**ALBUQUERQUE
PLANNING DEPARTMENT
May 28, 2008
DRB Comments**

PROJECT # 1007288

APPLICATION # 07-70223

RE: Tract 255, MRGCD Map # 38

**PLAT OF
LOTS 1 AND 2
HOLLYWOOD AVENUE DEVELOPMENT**

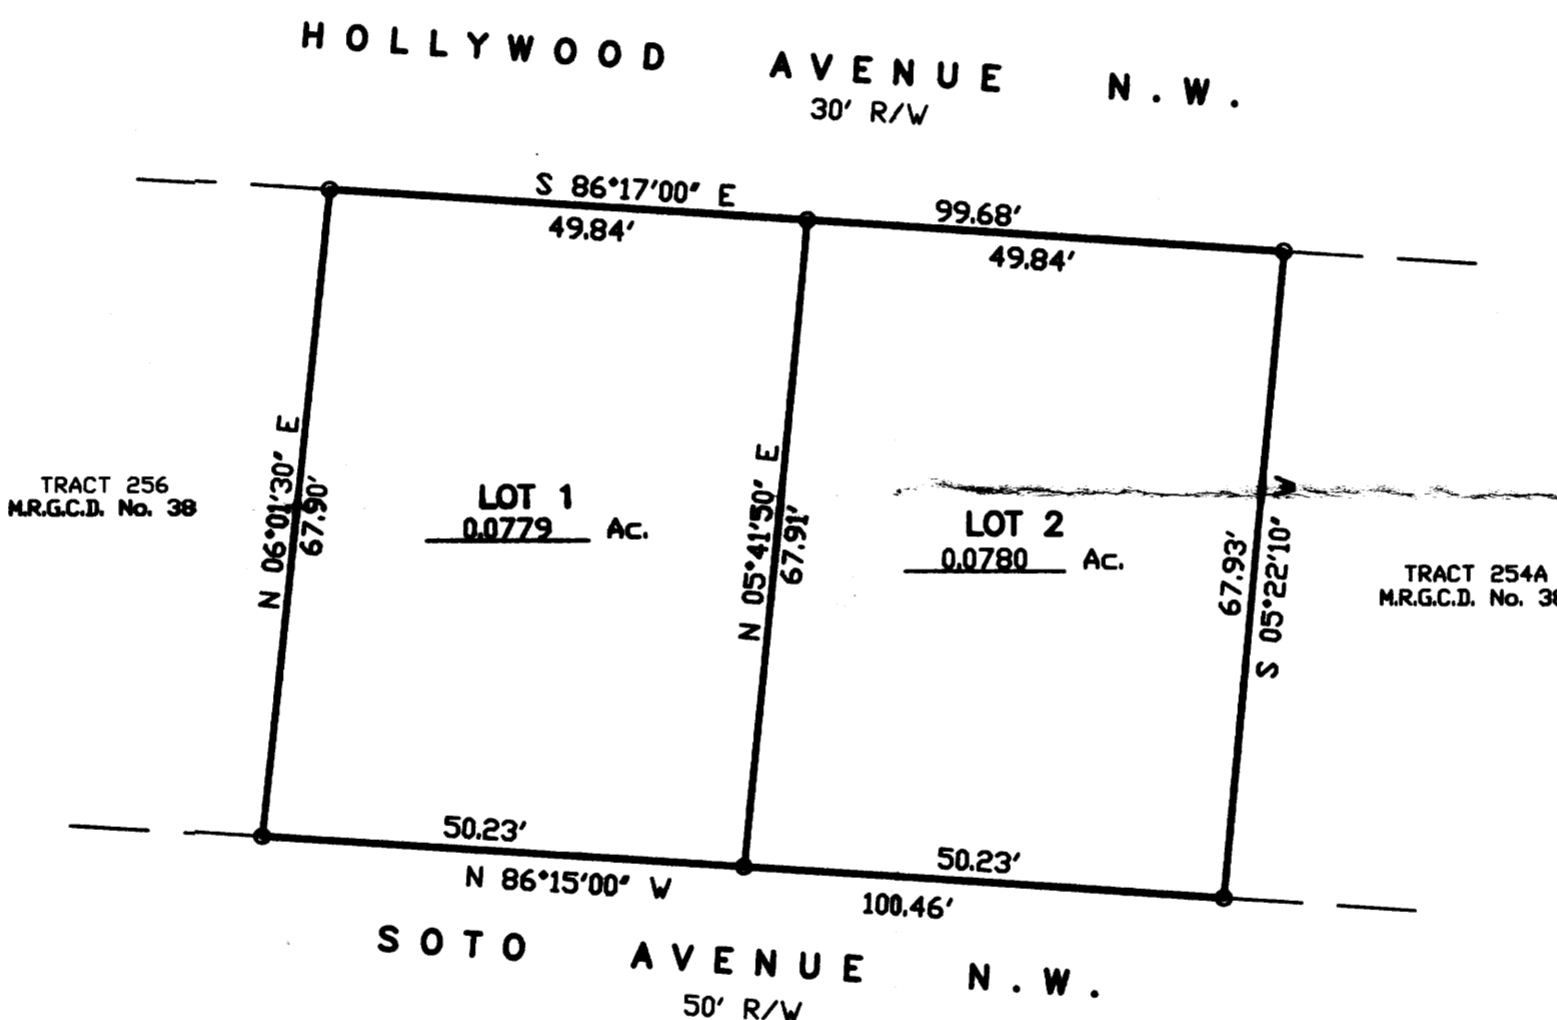
A Special Exception/ Variance for lot width and for lot area would have to be approved by the Zoning Hearing Examiner (ZHE) in order for the DRB to approve the proposed plat. You may contact Tom Rojas of the ZHE office at 924-3938.
